City of Sydney

24 June 2011

RE: Sydney University Abercrombie Precinct Redevelopment – Project Application (MP07_0158)

SITE PLAN

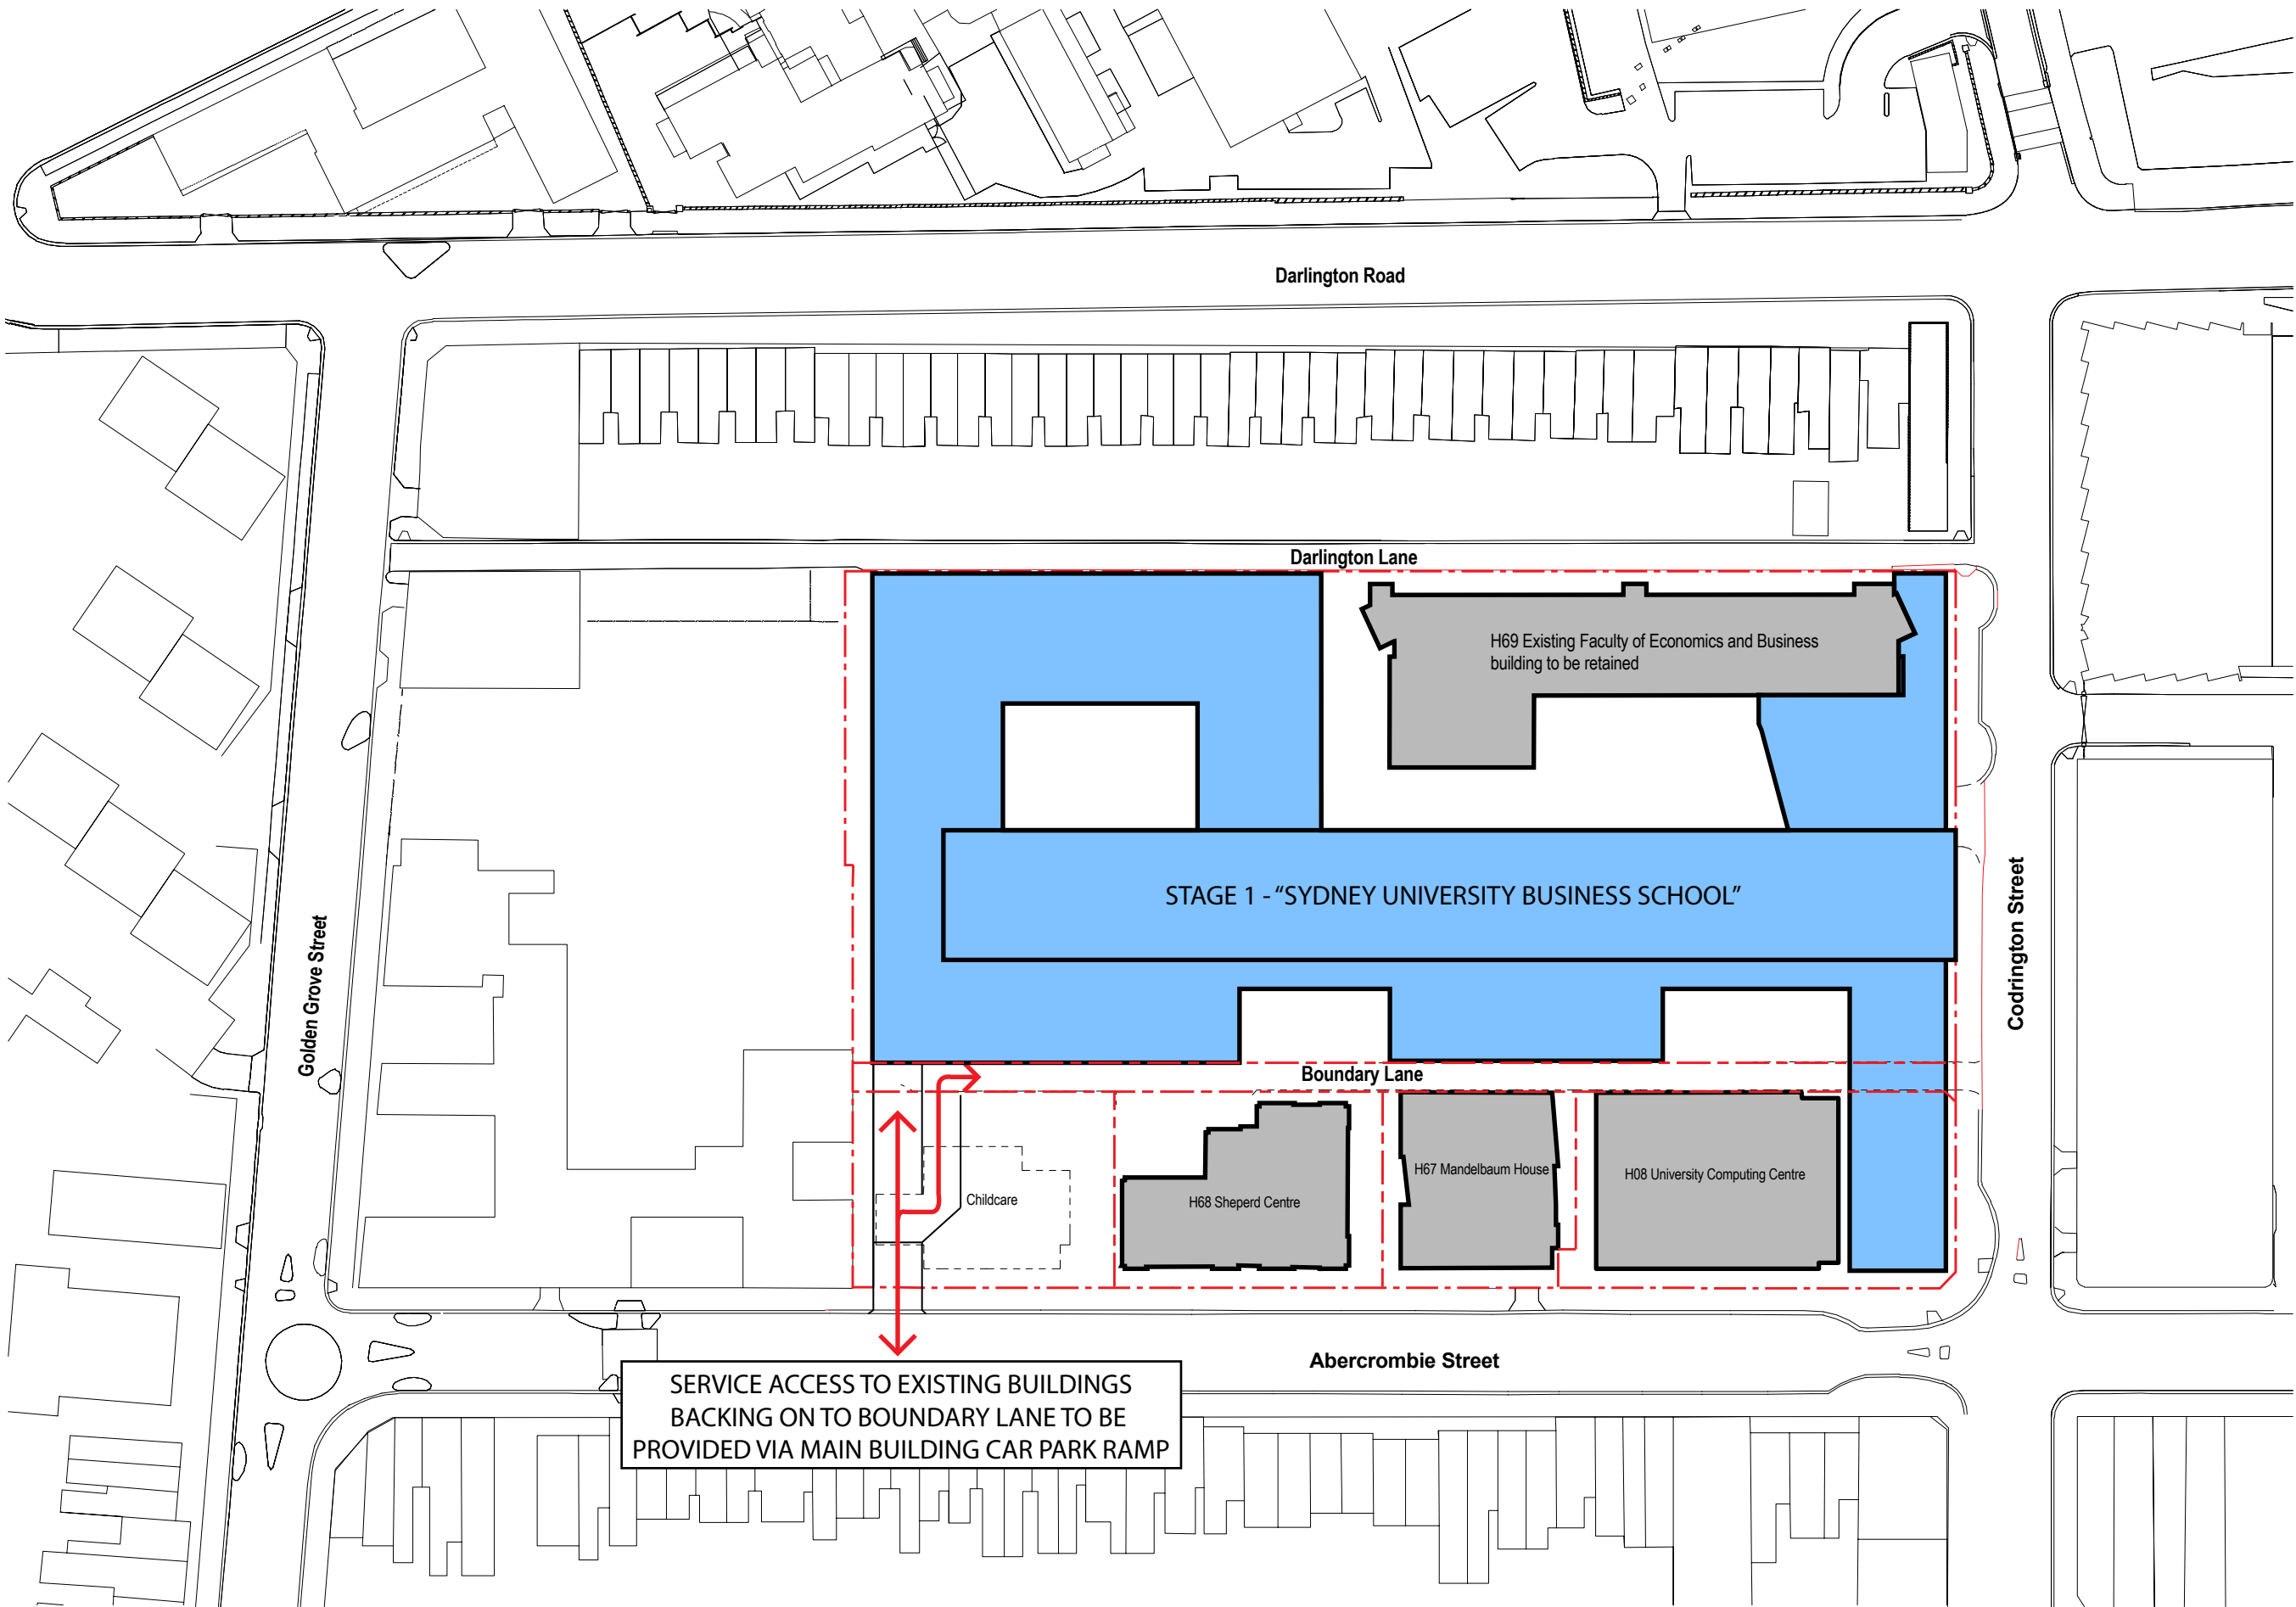
According to the Site Plan (A1002/3) prepared by Woods Bagot architects dated 9 March 2010, a new chamber substation is proposed in the rear of 105 & 106 Darlington Road. The Arborist Assessment states that within the rear yard of this property is a group of Lilly Pillies. The report states this group of trees has a high retention value.

The location of this new substation has not considered the likely impacts on existing vegetation. It is considered that several other locations could have been selected for this substation that would not require tree removal or impact on trees with high retention values

Description	Octave band centre frequency							Hz
	63	125	250	500	1k	2k	4k	
Truck 10-20km/hr	109	111	106	101	99	98	97	dBW

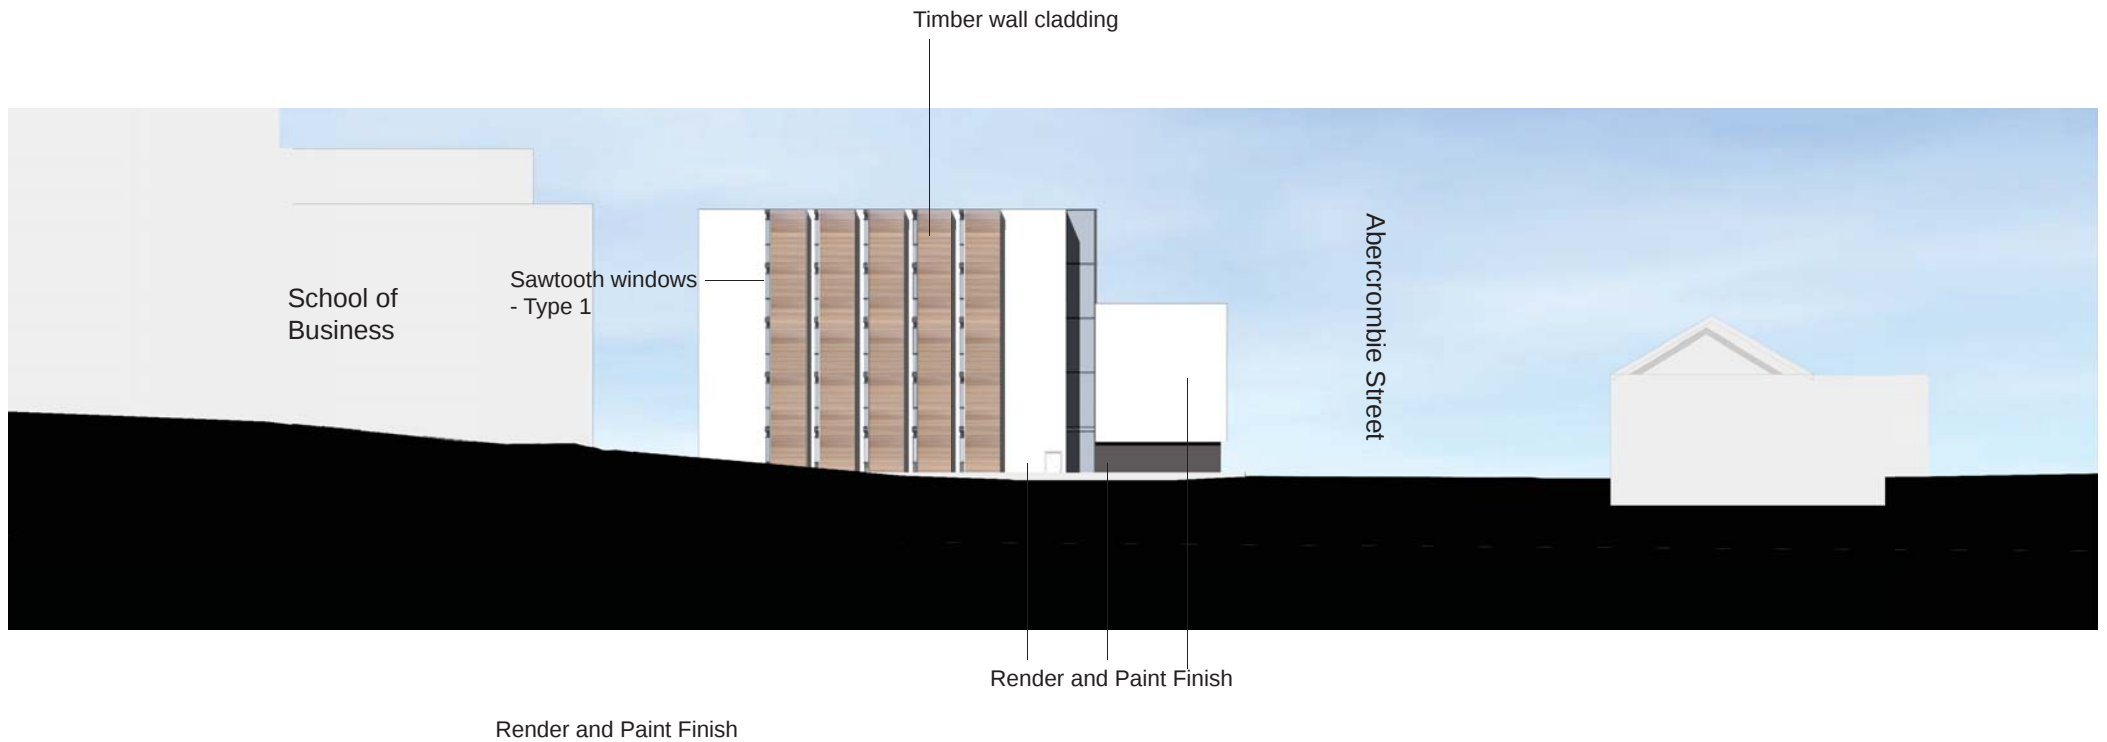
architecturally is contemporary in terms of massing, the strong horizontal lines of the exposed slabs that have been expressed on the street elevations fail to adequately respond to the fine-grain vertical character of the surrounding streets, and particularly along Abercrombie Street. The architectural character of the perimeter of the building needs to be amended by incorporating strong vertical articulation to ensure the buildings along Abercrombie Street harmonize with the character of the Victorian terraces.

The proposal has the potential to integrate well with the neighbourhood in that it has adopted a scale along the perimeter of the site which is not incompatible with its context. However in order to respect and respond appropriately to its context, further vertical emphasis in the facades is considered necessary.
